Ribble Valley Borough Council
Housing & Development Control

Application no: **3/2023/0294**

Address: **70 Mellor Brow Mellor BB2 7EX**

Proposal: **Proposed demolition of existing bungalow and garage and construction of replacement bungalow and garage.**

Site Plan - Proposed

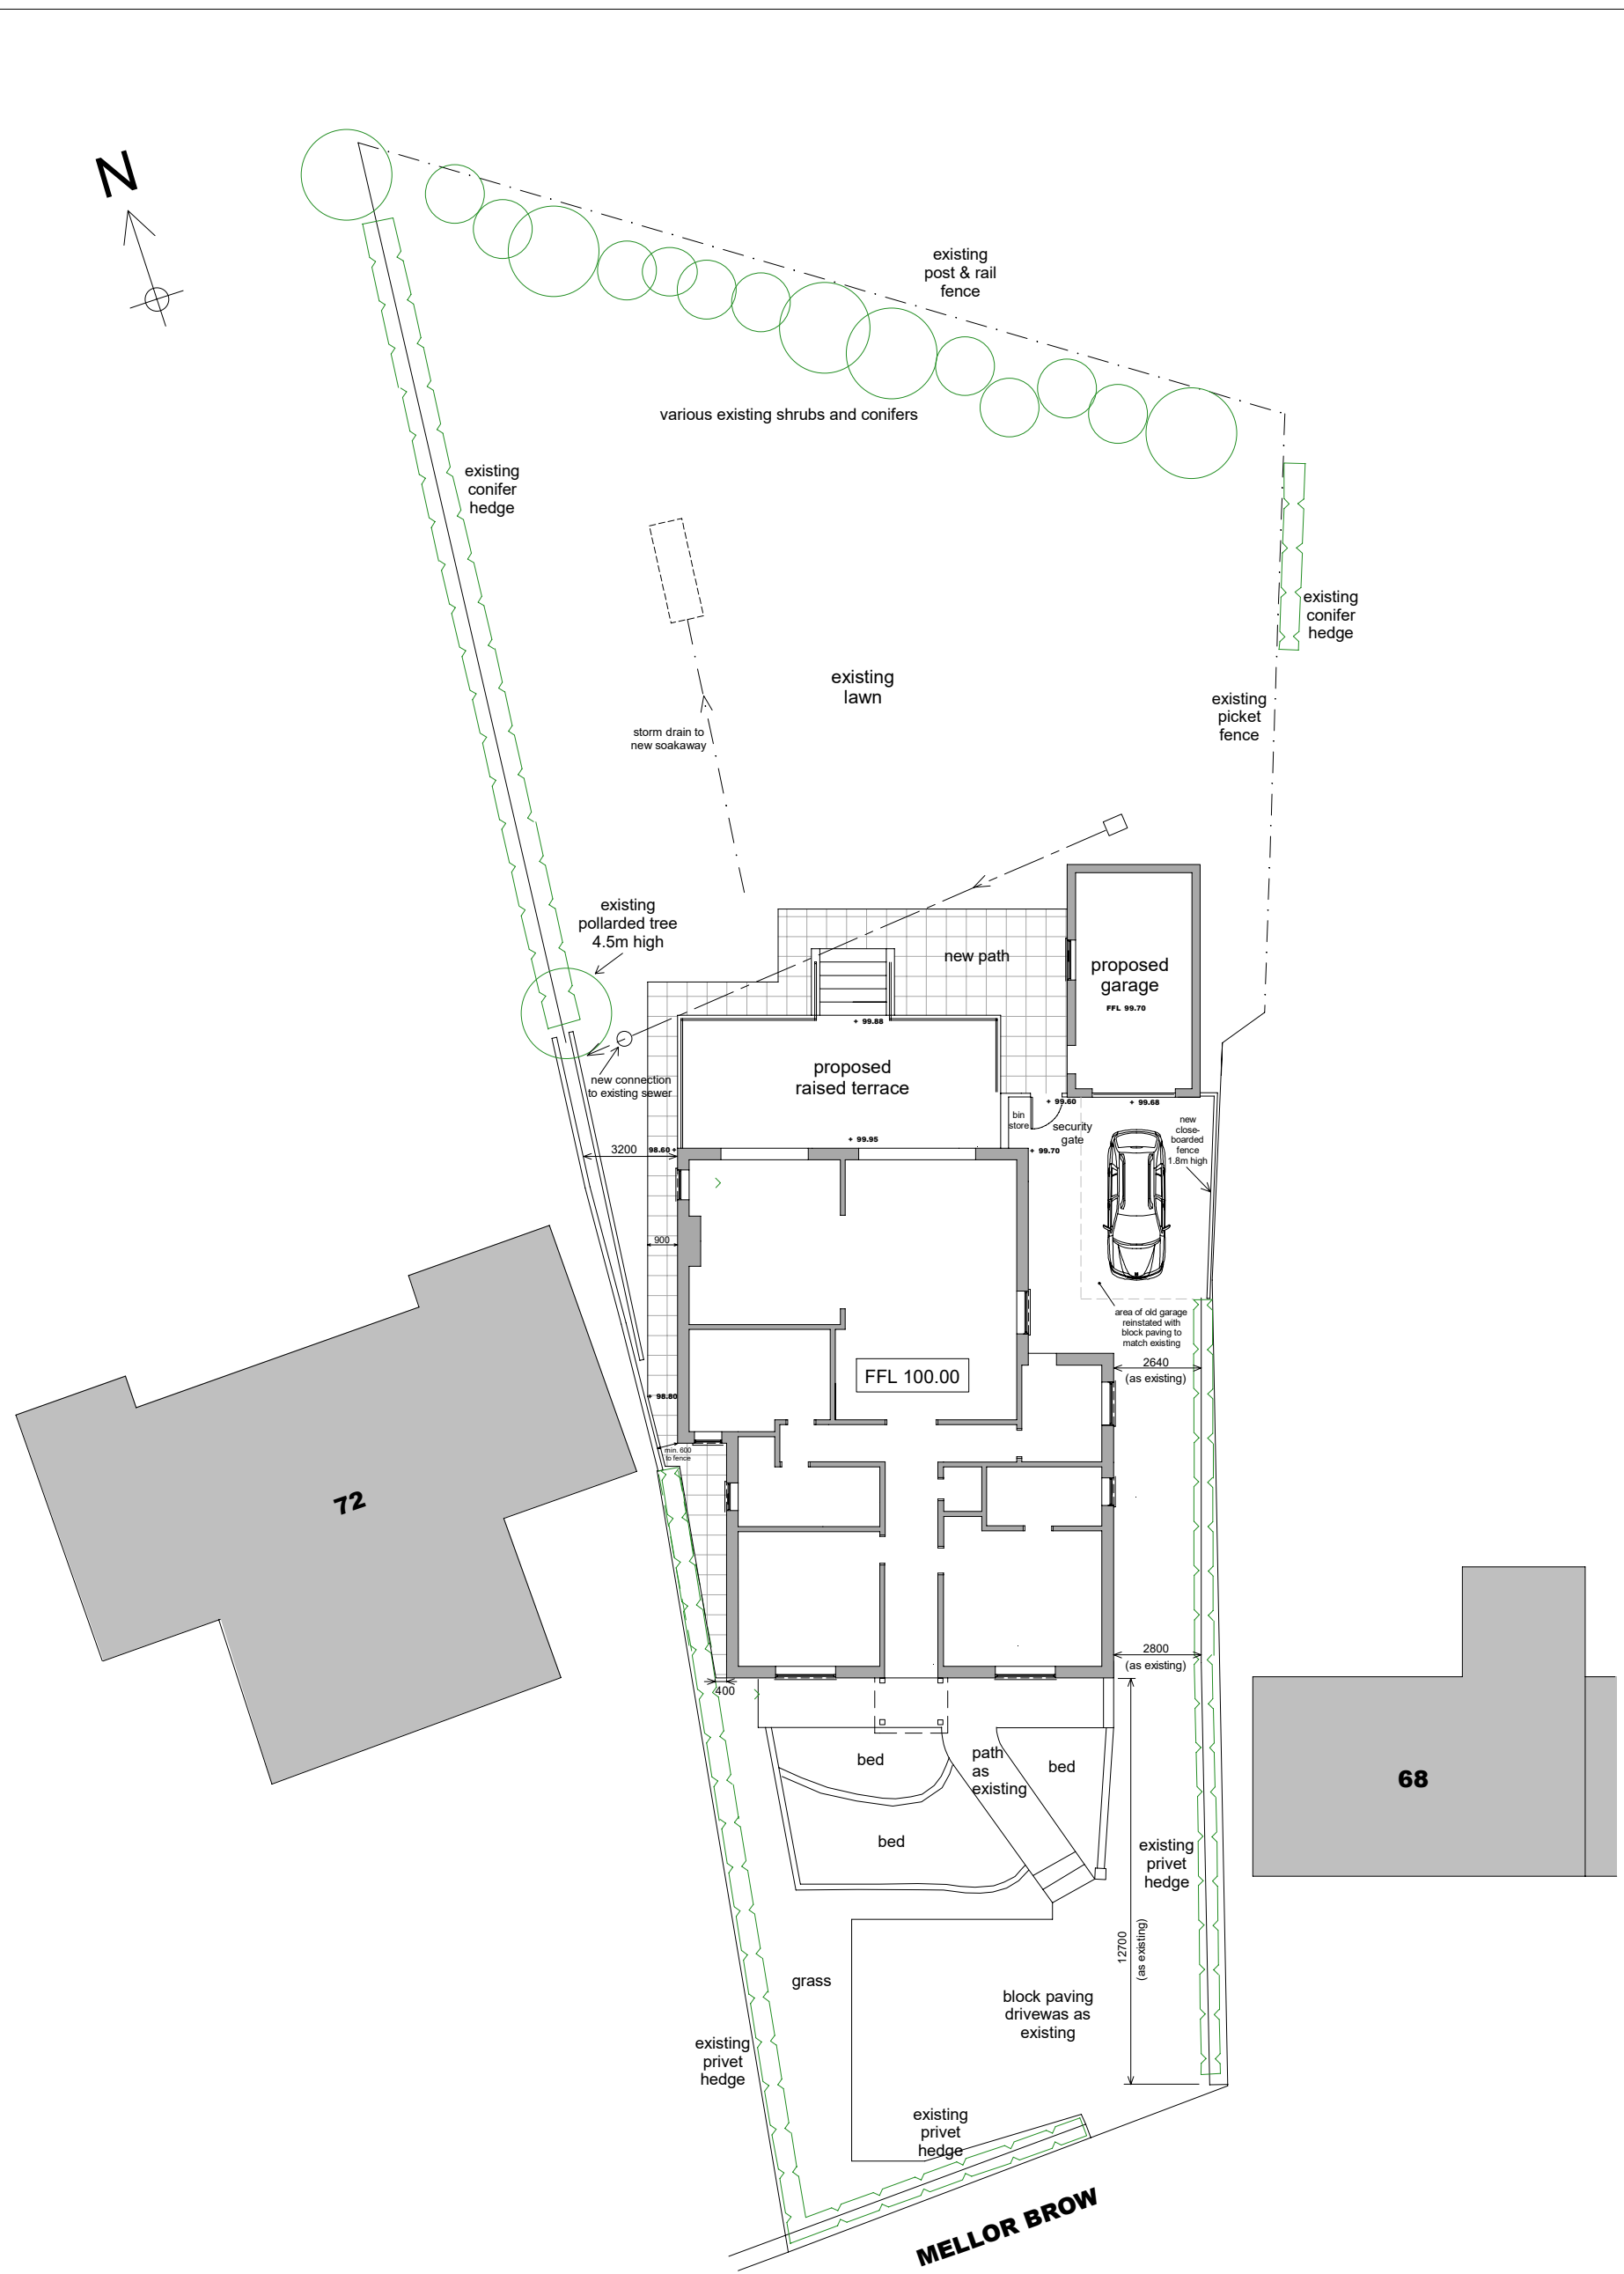
The LHA have reviewed Anderson drawing number 163/P/02 Rev A titled "Proposed Plans and Elevations" and are aware that the access which currently serves the dwelling will remain unaltered following the proposal. Therefore, given that the access is already existing, the LHA have no concerns regarding the usability of the access.

The LHA have reviewed Anderson drawing number 163/P/02 Rev A titled "Proposed Plans and Elevations" and are aware that the site can provide a minimum of 2 car parking spaces to comply with the LHAs parking standards as defined in the Joint Lancashire Structure Plan.

The LHA will condition that a minimum of one space has access to an electric vehicle charging point and the site provides some form of cycle storage facility.

2. The development hereby permitted shall not be occupied until such time as the parking and turning facilities have been implemented in accordance with Anderson drawing number 163/P/02 Rev A. Thereafter the onsite parking provision shall be so maintained in perpetuity.

3. The garage facility shall include provision of an electrical supply suitable for charging an electric motor vehicle.

4. No building or use hereby permitted shall be occupied or the use commenced until a cycle storage plan for the residential unit has been submitted to the Local Planning Authority, in consultation with the Local Highway Authority. These cycle facilities shall thereafter be kept free of obstruction and available for the parking of bicycles only at all times.
